BCA REPORT
Concept Design Phase

Taronga Zoo
The African Savannah & Congo Precinct

Revision: 0
13 March 2017
Project No.: 160436

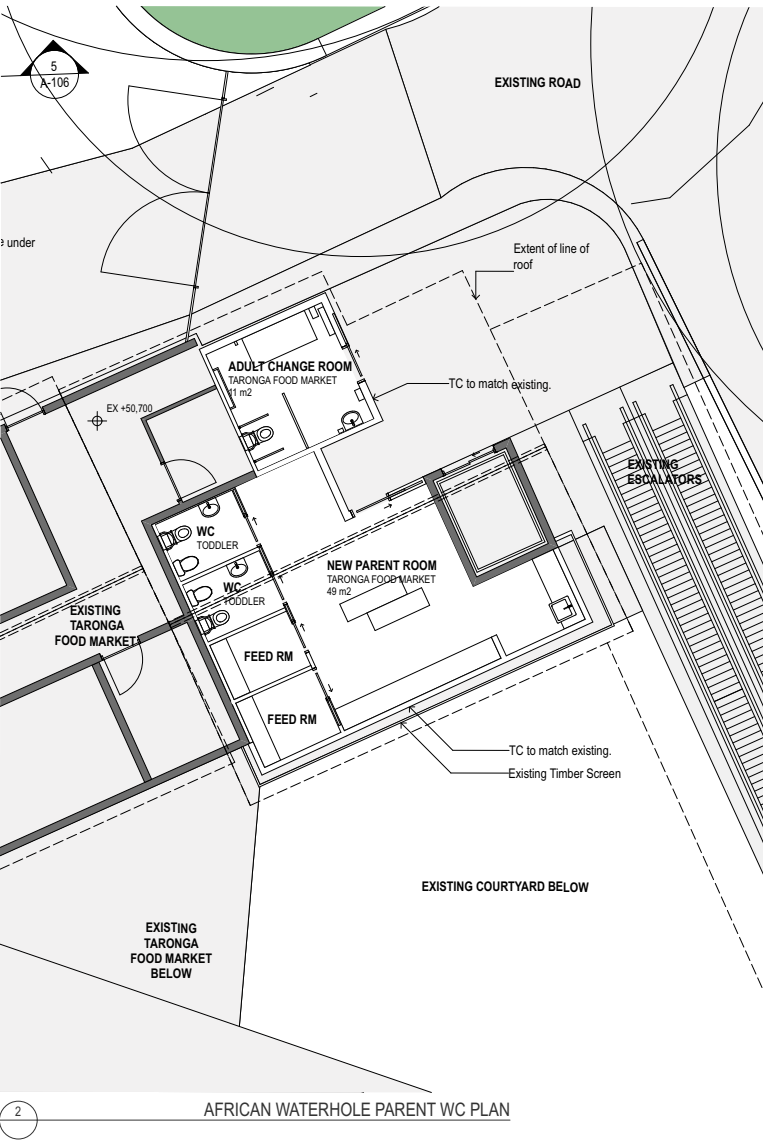
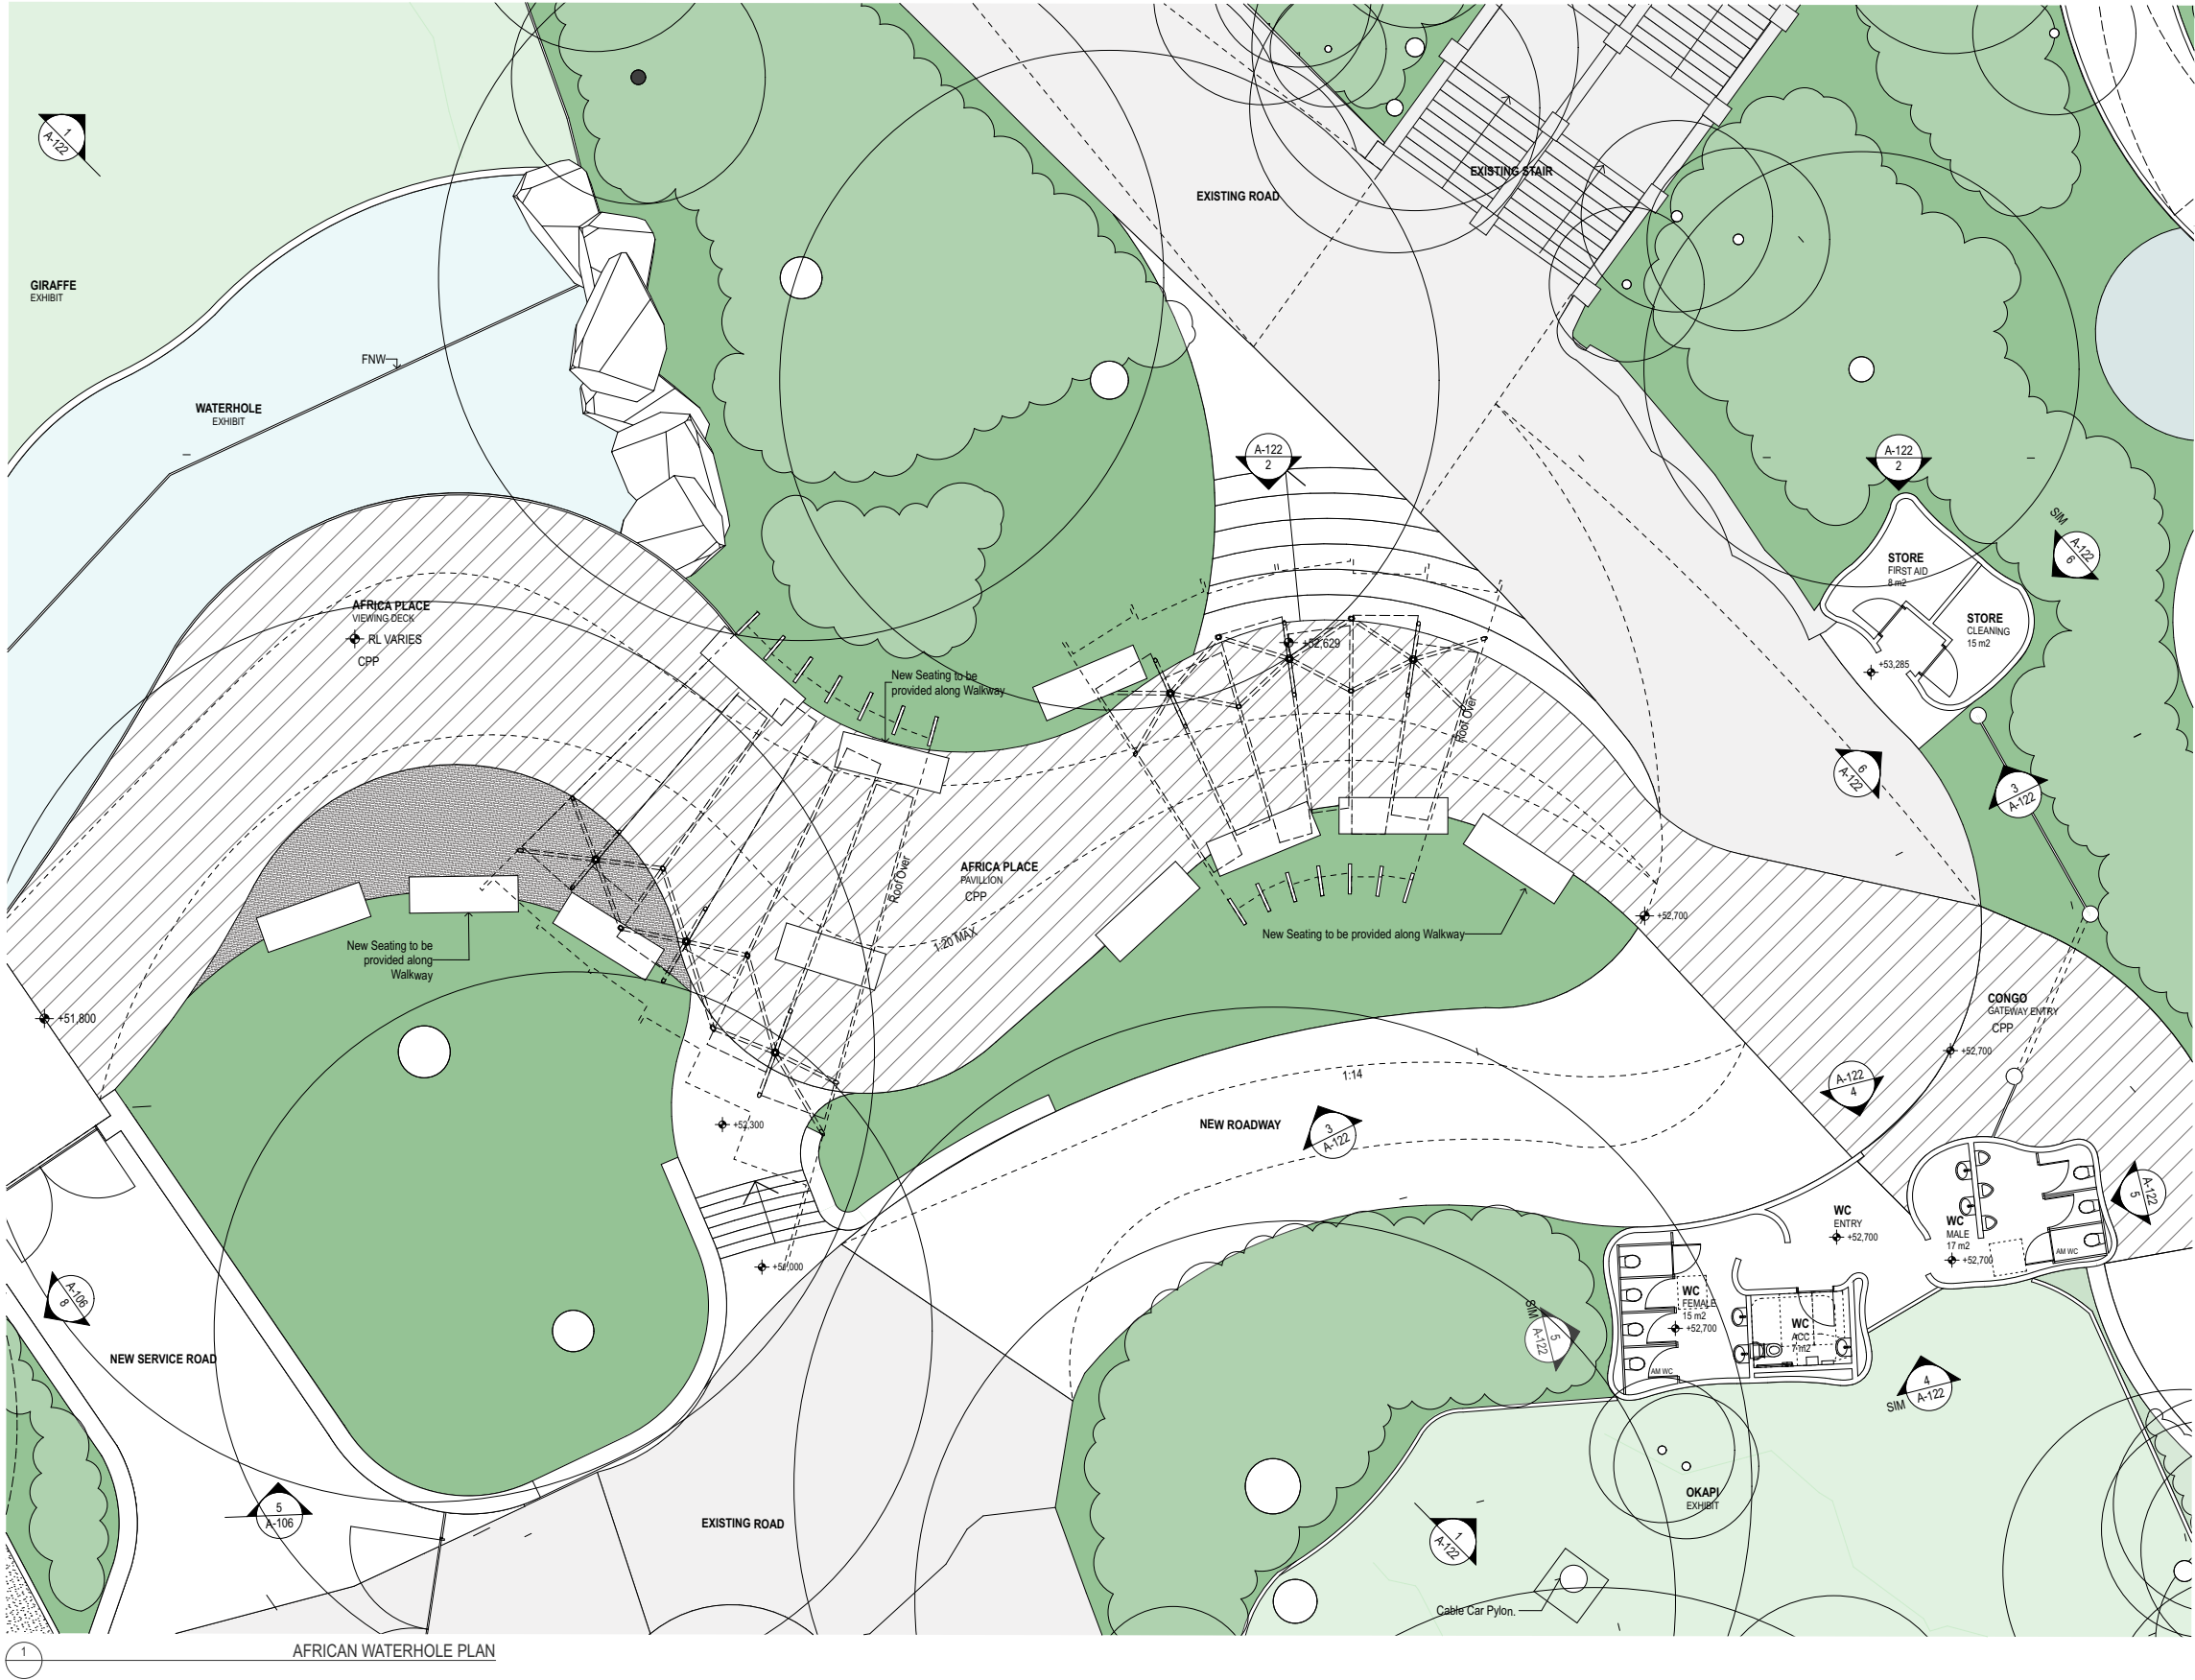
- Separate male and female toilet facilities are proposed in accordance with the BCA requirements with the exception of the washbasins which are proposed to be communal. This arrangement does not comply with

BCA deemed-to-satisfy provisions, and it is considered that the proposed location of the communal basins could not be supported under a Performance Solution.

1 SECTION 1 - GIRAFFE AND ZEBRA BOH CROSS SECTION

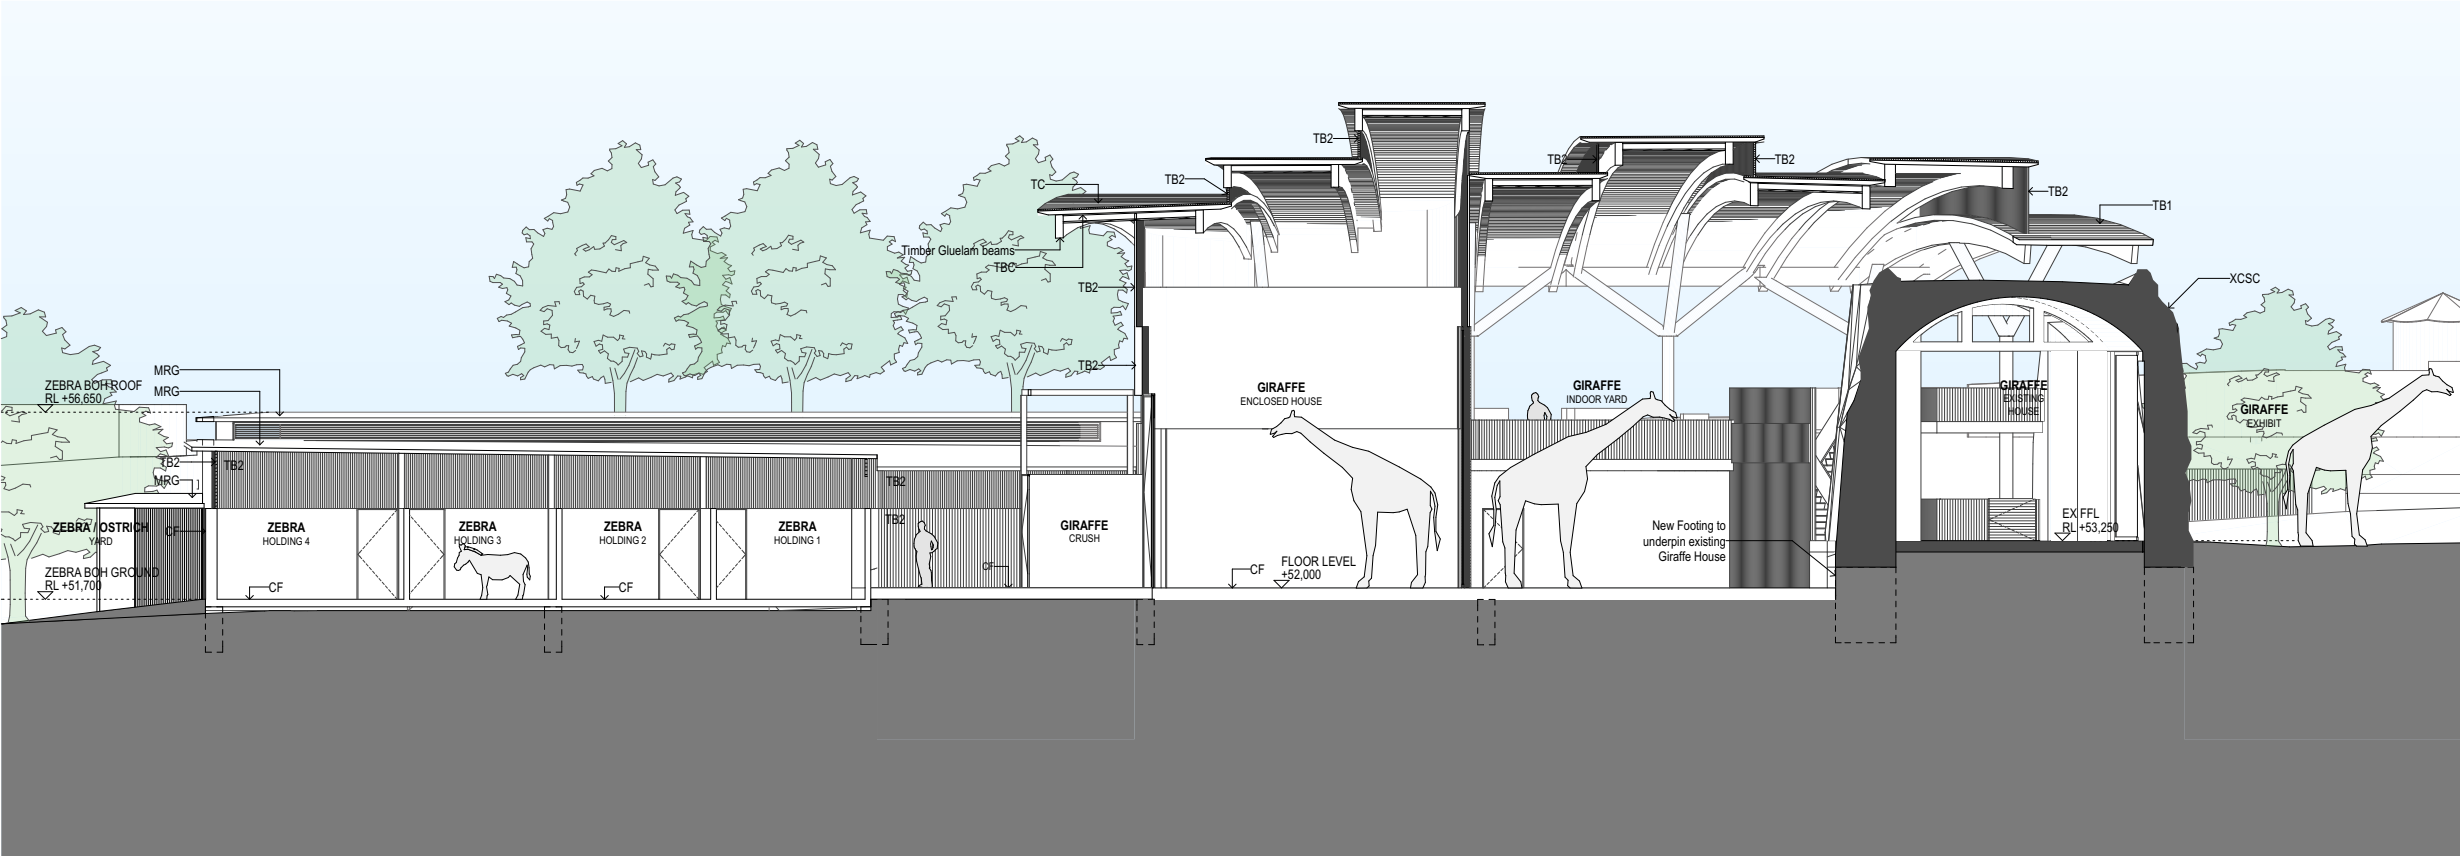
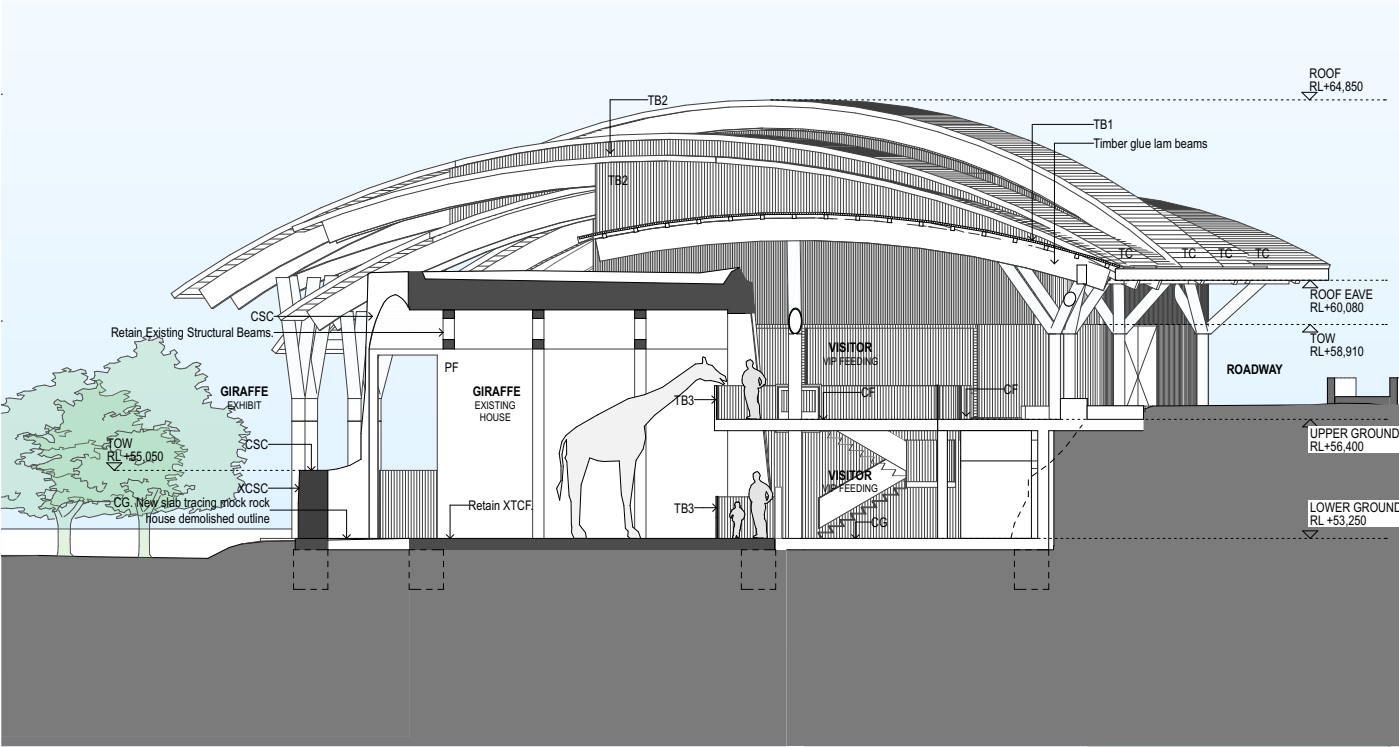
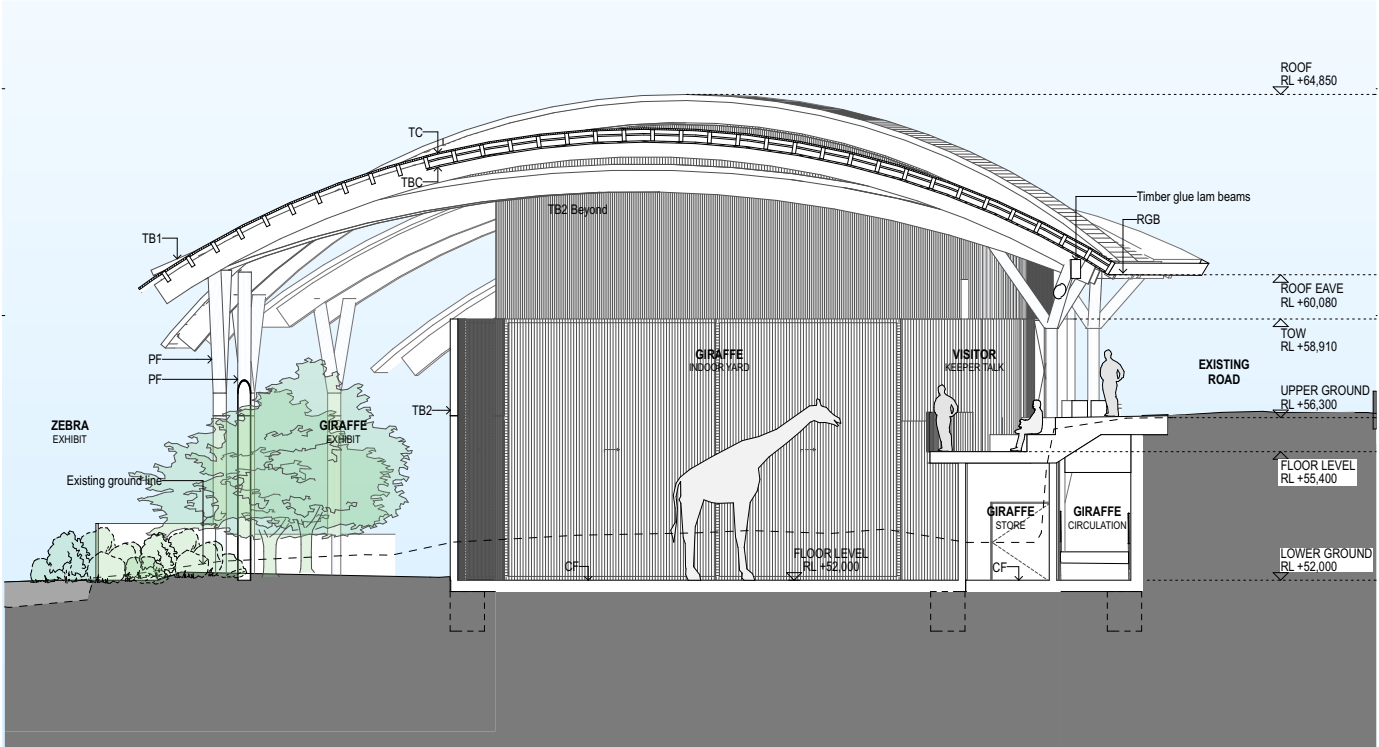
With respect to the Giraffe/Zebra Exhibit, as Type B Construction applies, fire resisting c is required in accordance with clause 4 of BCA Specification C1.1. In summary, the following minimum fire ratings are required:

- + External walls (>18m from FSF): No FRL
- + Loadbearing internal walls and columns (Lower Ground Floor): 120/-/- FRL
- + Floor separating Lower & Upper Ground Floors: 30/30/30 FRL
- + Loadbearing internal walls and columns (Upper Ground Floor): No FRL
- + Roof: No FRL
